Ribble Valley Borough Council

Address: Land at Higher Standen Farm and Part Littlemoor Farm Clitheroe

Proposal: Reserved Matters application in respect of Phase 5 and 6 to include access, appearance, landscaping, layout and scale with respect to 300 dwellings following outline approval 3/2015/0895.

Further to our previous comments dated 16th May 2022, the amended plans 'Taylor Wimpey Site Layout Phase 5 & 6 composite TW/HSF/SL/01/Rev Q' and 'Taylor Wimpey Adoptable Highways Plan TW/HSF/AHP/01/Rev E' have been reviewed and the following comments are made.

Adoptable Highways Plan - Phases 5 & 6

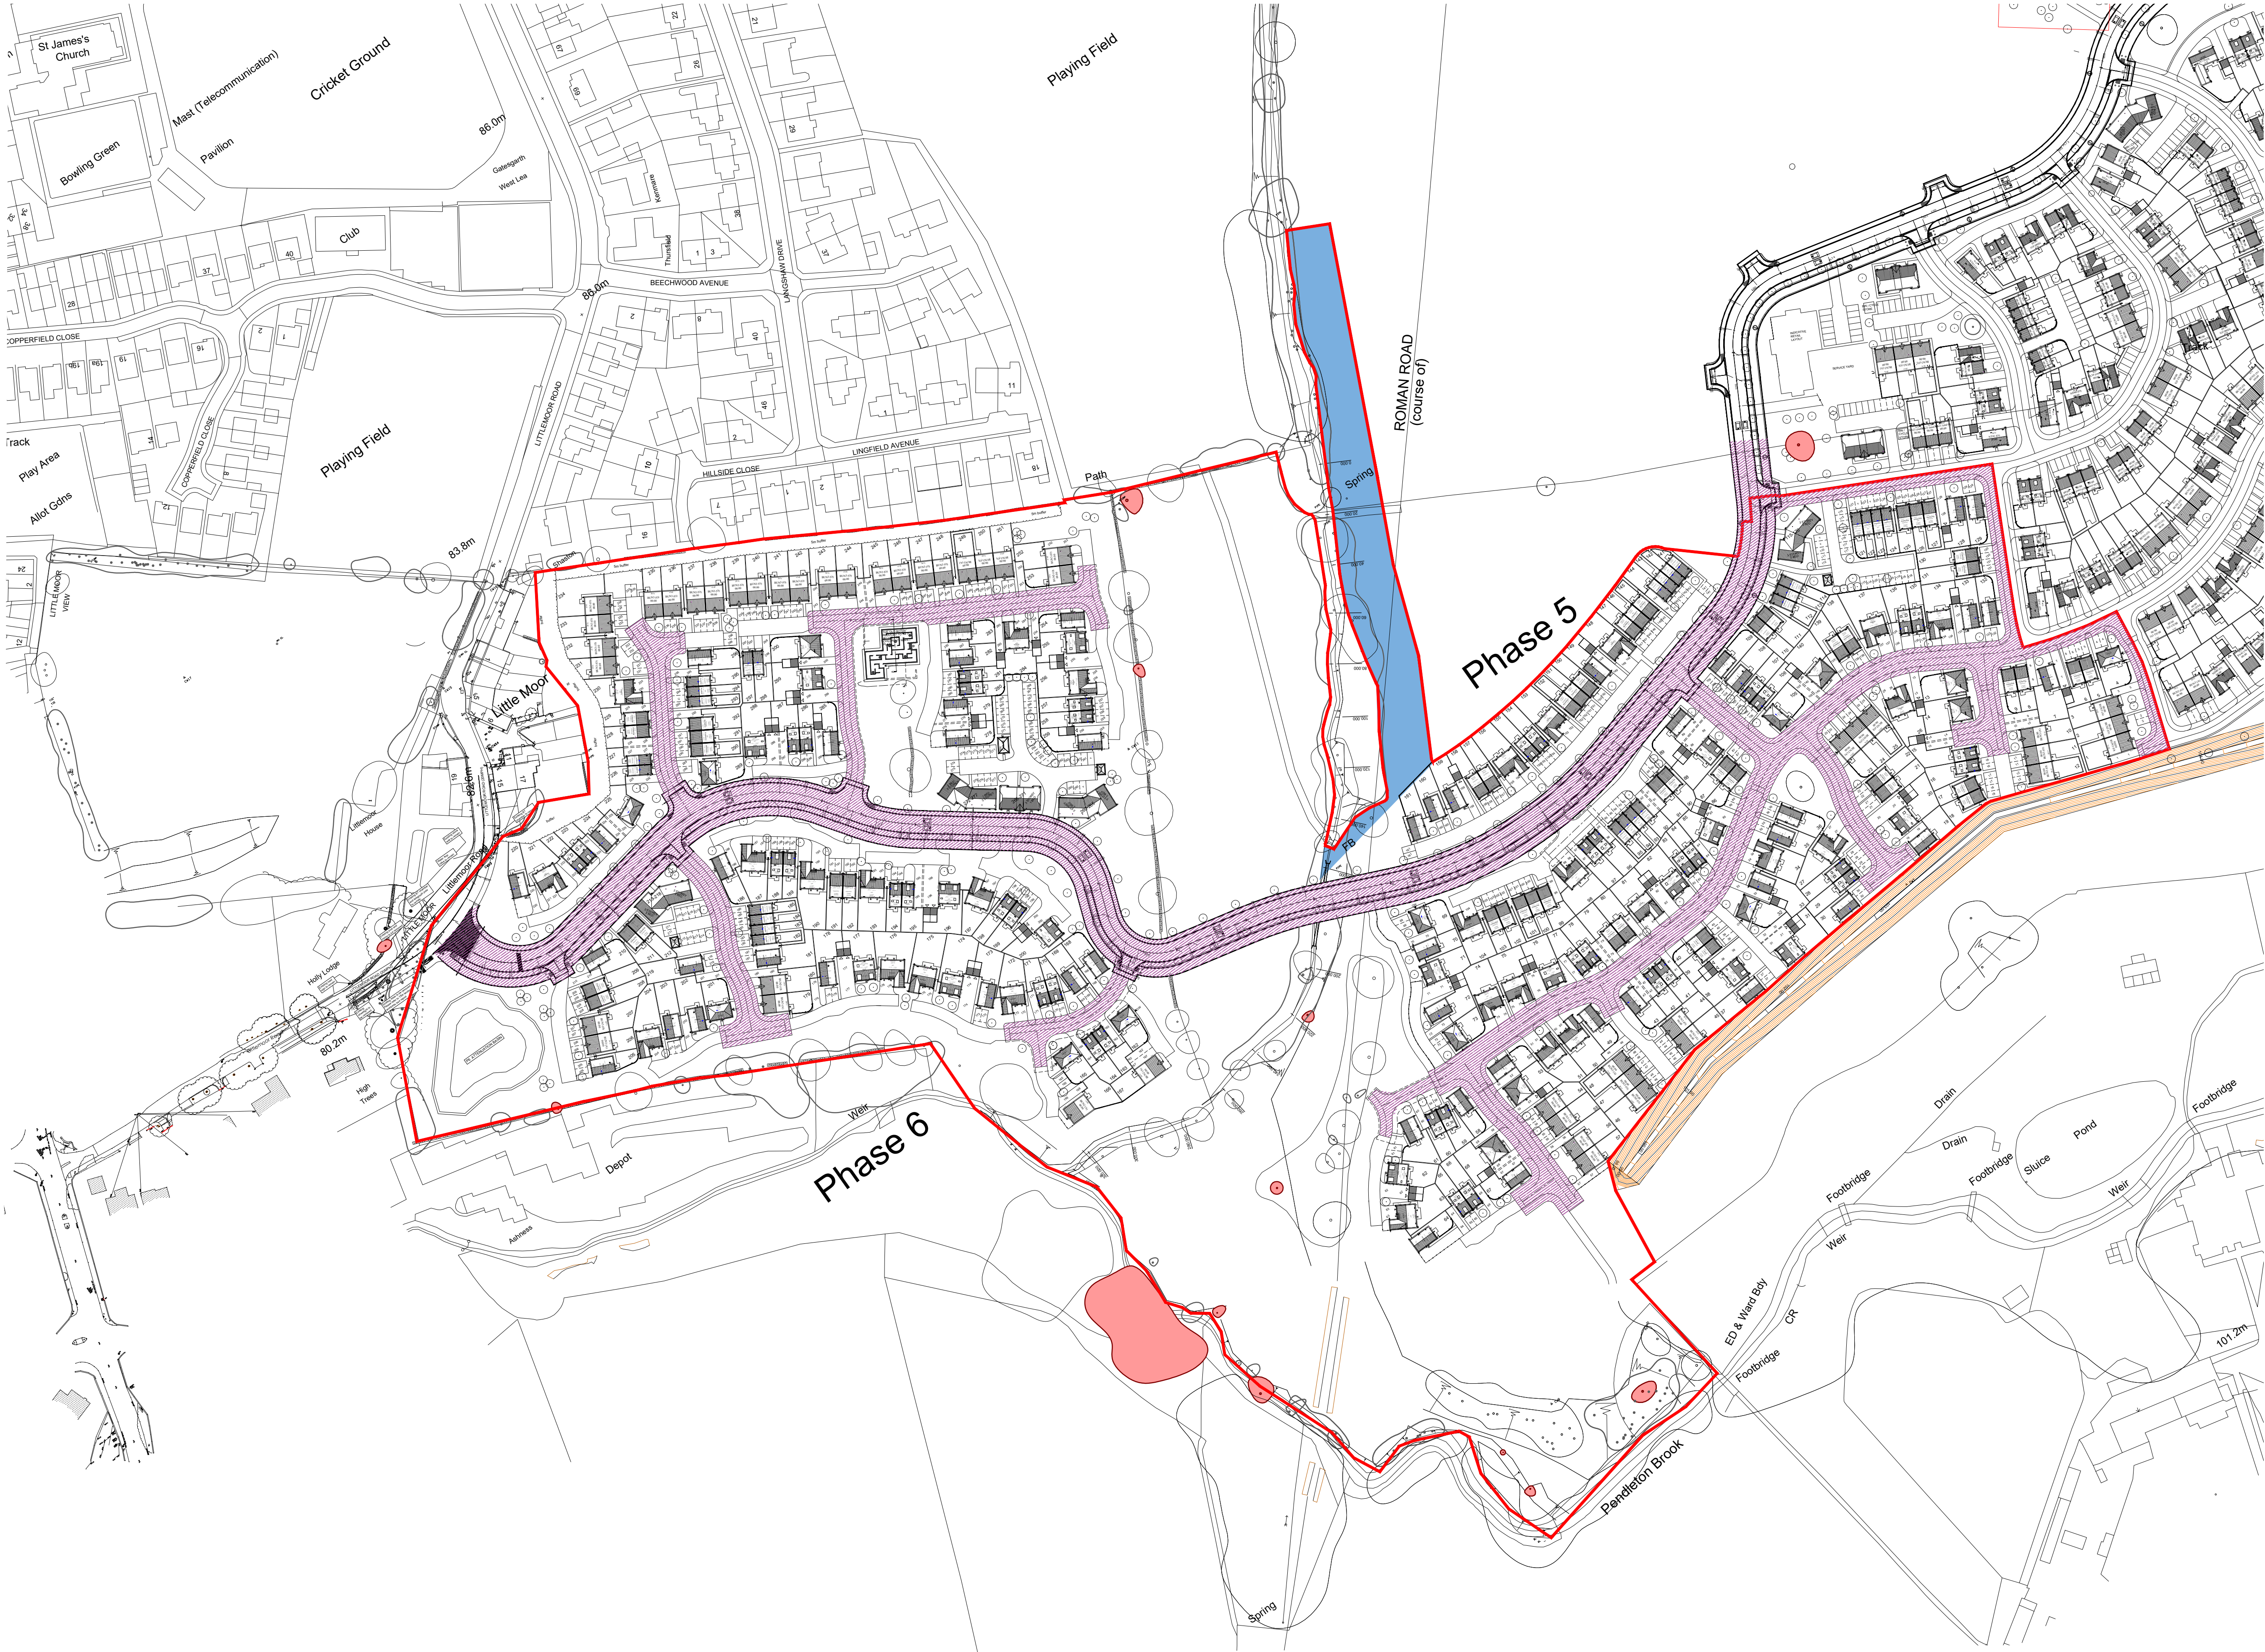
The submitted layout for phases 5 and 6 includes direct driveways onto the spine road for plots 70-77, 95-99, 155, 171-176, 190-195 on the south side and plots 199, 220-226 and 262-265 on the north side.

For the south side this will require a large number of the trees to be removed from the scheme which are sited in the verge to the south side of the carriageway to ensure visibility splays at the driveways are provided.

The additional driveways on the south side will cause additional movement across the shared footway/cycleway which will be detrimental to pedestrian and cycle movements. We would request that the majority of the direct driveways are removed from the scheme.

A number of uncontrolled pedestrian crossing points (dropped kerb/tactile paving) need to be provided to allow pedestrians to cross the spine road on the desire lines. These are most likely to be located close to the side road junctions and where public footpaths cross the spine road.

Trees should be removed from the visibility splays.

FP14 crosses the spine road, please could further details be provided to show how the FP ties into the spine road and are any improvements to FP 14 proposed.

Bus cushions are included on the spine road which appear to accord with the guidance.

There are a number of trees located in the visibility splays of the estate road junctions, private drive junctions, pedestrian crossing points and curves on the spine road, these need to be removed from the drawing. The speed limit on the spine road will be set at 20mph and visibility splays of X2.4m by Y25m should be provided.

Swept path analysis is requested for all the turning heads for a 11.2m long refuse vehicle.

A turning head needs to be provided close to the Little Moor Road junction to allow unauthorised vehicles (all vehicles other than emergency, buses and cycles) to turn and exit onto the spine road towards Pendle Road.

Additional signage is required on the approach to the turning head to alert drivers of unauthorised vehicles to turn around.
